RE: **Shawn McWethy Park – Phase I**
Grading Plan
Engineer's Stamp Date 12/16/16
Hydrology File: J09D023A

Based upon the information provided in the submittal received on 4/20/17 the above-referenced Grading Plan is not approved for Grading or Paving Permit. The below items must be addressed prior to approval.

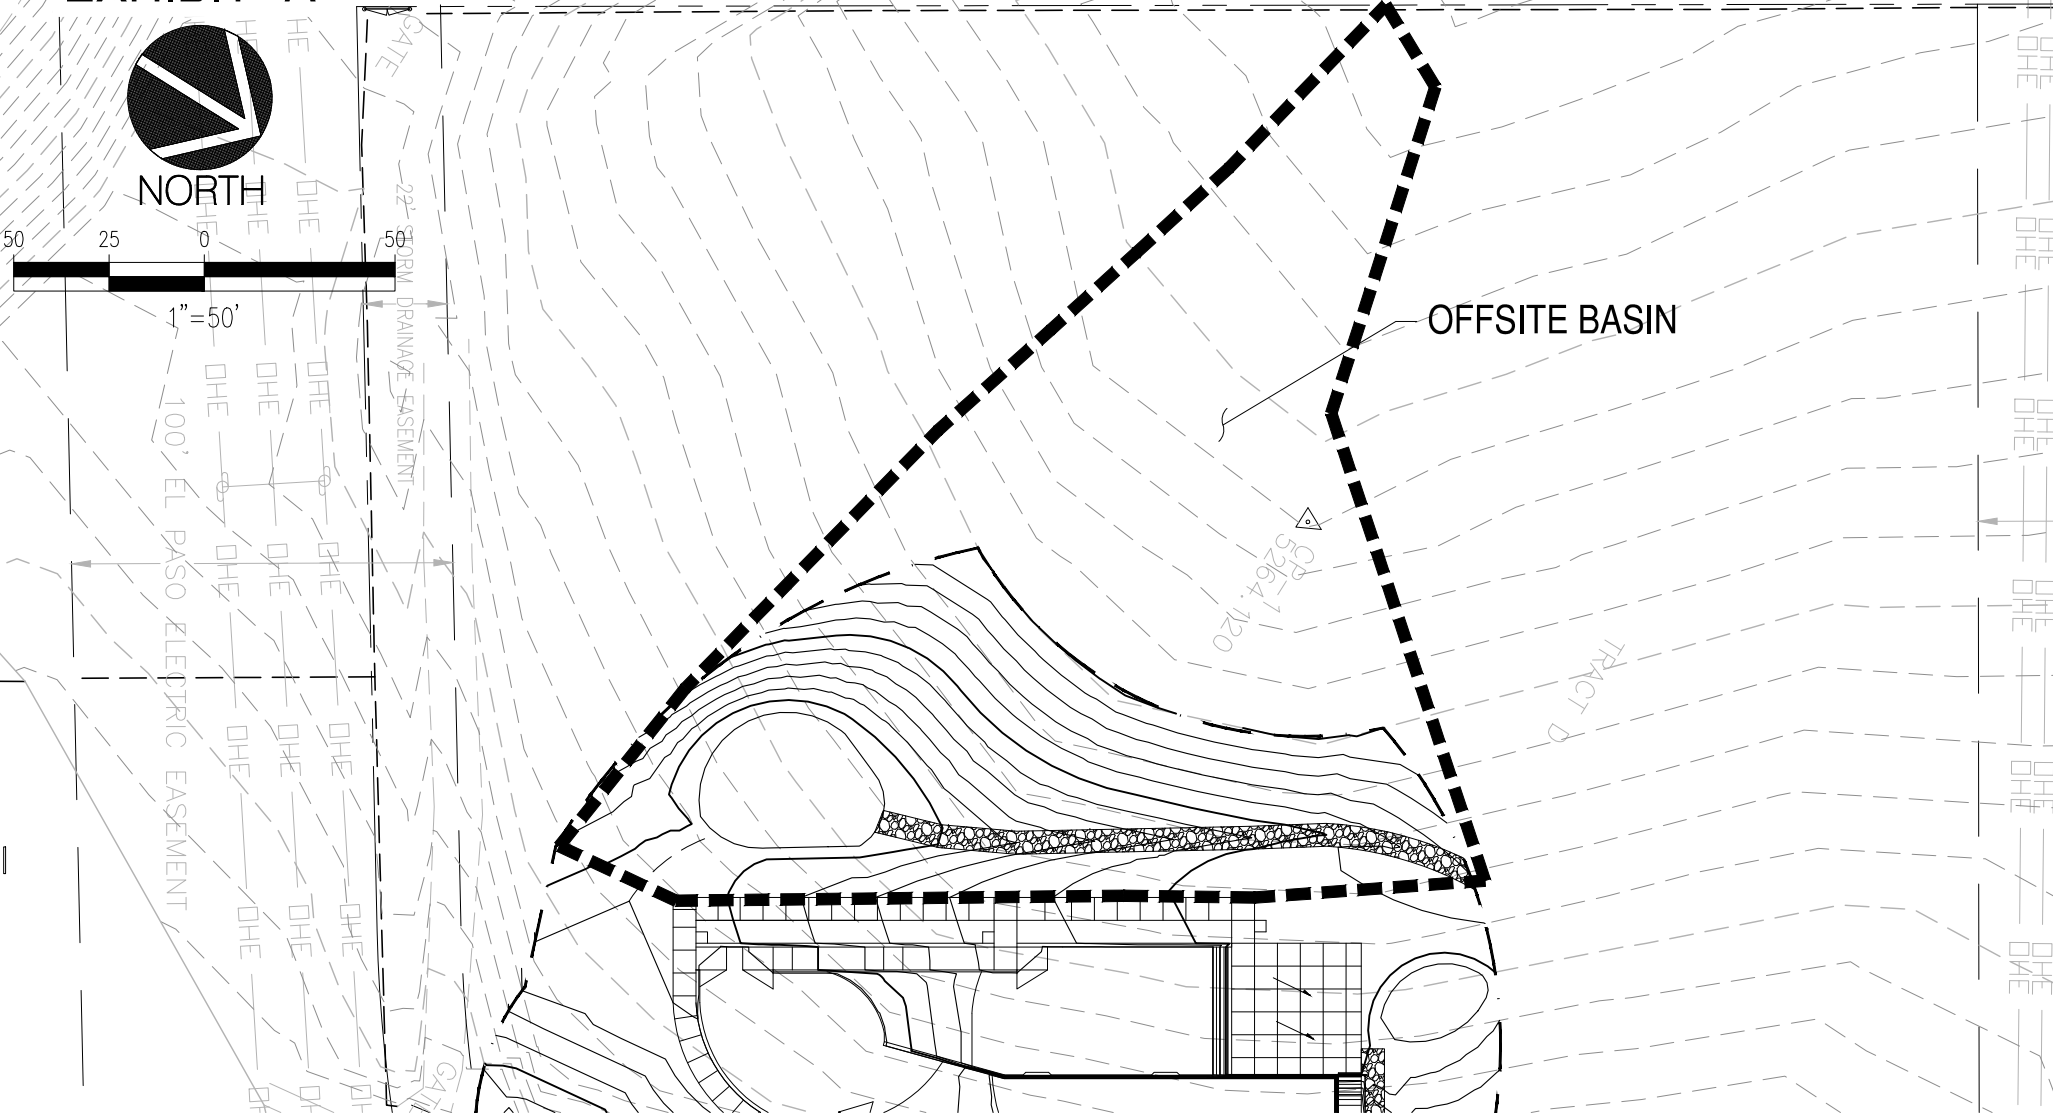
1. Keyed note 8 directs to Detail C; however section A-A for the same swale directs to Detail A. Verify which swales are being placed where.
2. The south pond appears to be 1ft deep and ~40ft across; however the claimed volume is 4375CF. Include top of pond (water surface) and provide pond volume calculations to support the pond volume claimed. Also correct the 5250' contour along the east side of the pond.

3. The south swale needs to extend to the north property line to divert offsite flows away from the new sidewalk/patio area.
4. The north pond has no associated volume or calculations.

5. The north swale has flowlines set against the new sidewalk; adjust contouring to match the detail and keep the flow line off the new sidewalk.
6. Volume and runoff calculations including consideration of offsite flows, need to be included to support the sizing of the ponds and swales.

7. The storm water quality volume from the new impervious area needs to be captured and retained.
